22 April 2025

The Secretary
NSW Department of Planning, Housing and Infrastructure

SSD-70818708 DHL Logistics Facility, Badgerys Creek (South)

TITLE	GF PLAN - STAGE 1
DATE	17/12/2025
SCALE	1:750 @ A1 1:1500 @ A3
PROJECT NO.	21254
DWG NO.	DA101
REVISION	11

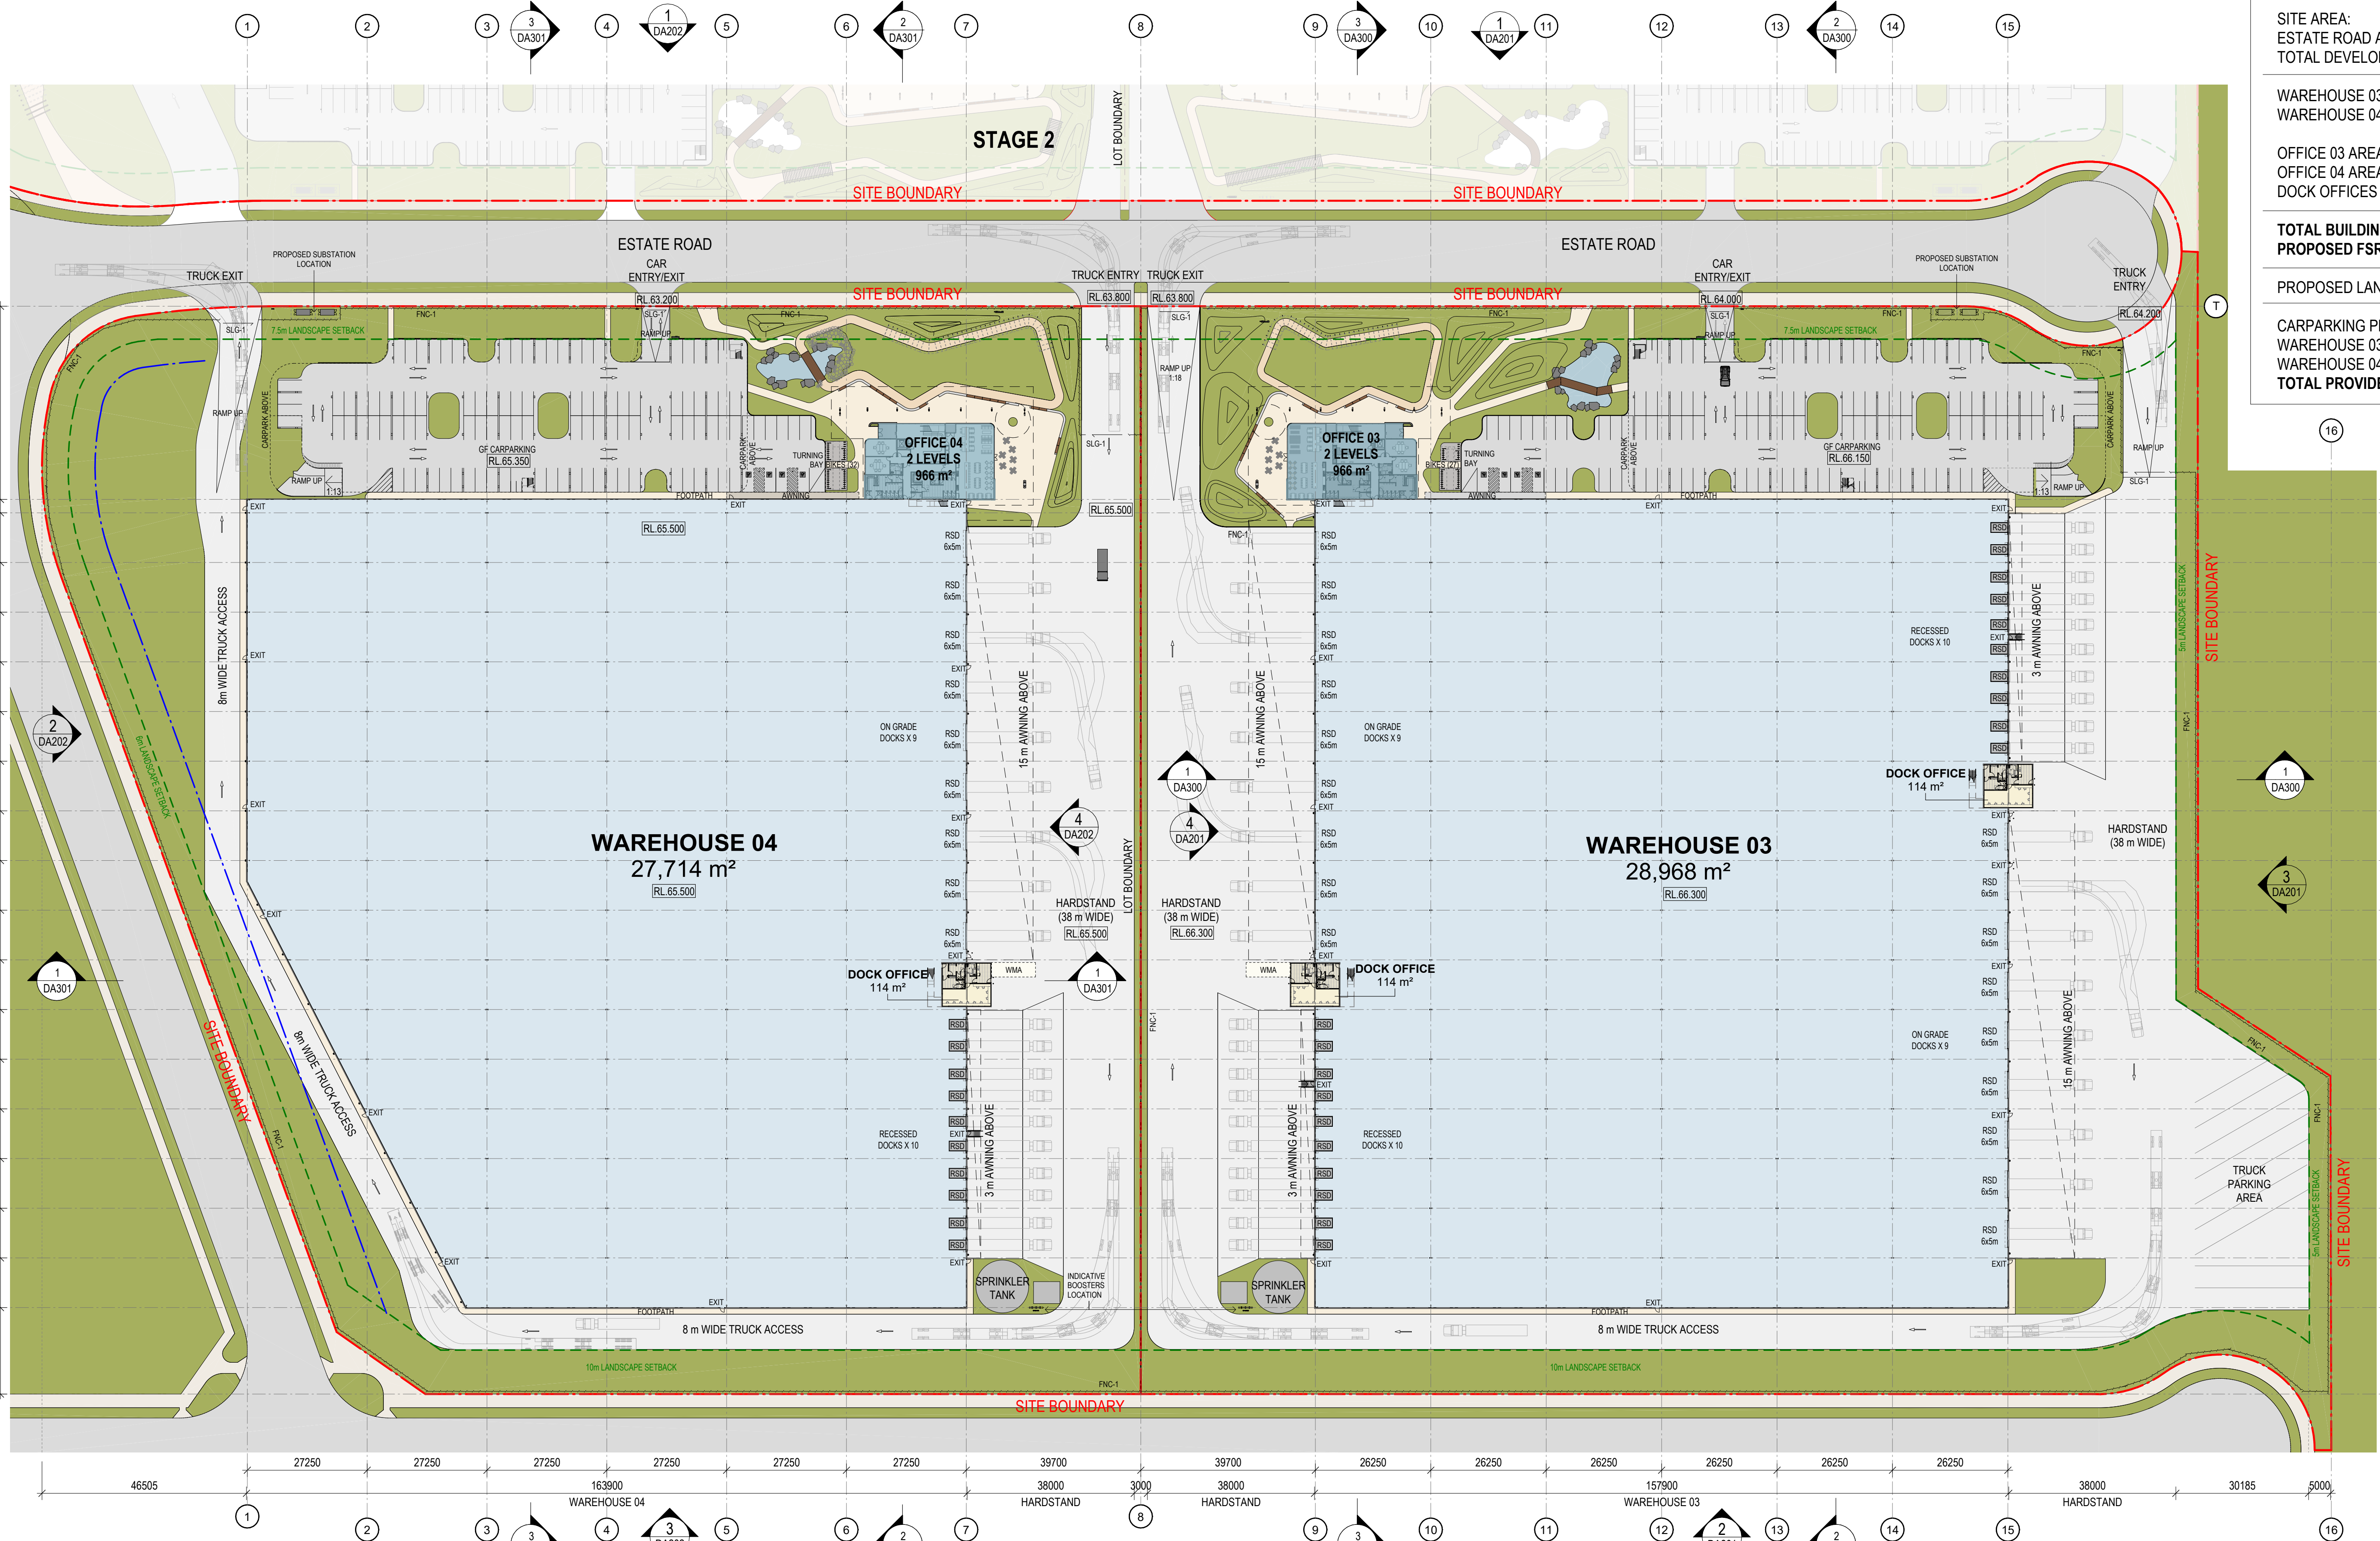
The below copy of the GF Plan – Stage 1 shows two ‘Proposed Substation Location’. Any required padmount substation/s will need to be located within the property (in a suitable and accessible location) and be protected (including any associated cabling not located within a public road / reserve) with an appropriate form of property tenure as detailed in the attached copy of Endeavour Energy’s ‘Land Interest Guidelines for Network Connection’.

Generally it is the Level 3 Accredited Service Provider’s (ASP) responsibility (engaged by the developer) to make sure substation location and design complies with Endeavour Energy’s standards the suitability of access, safety clearances, fire ratings, flooding etc. If the substation does not comply with Endeavour Energy’s standards, the applicant must request a dispensation.
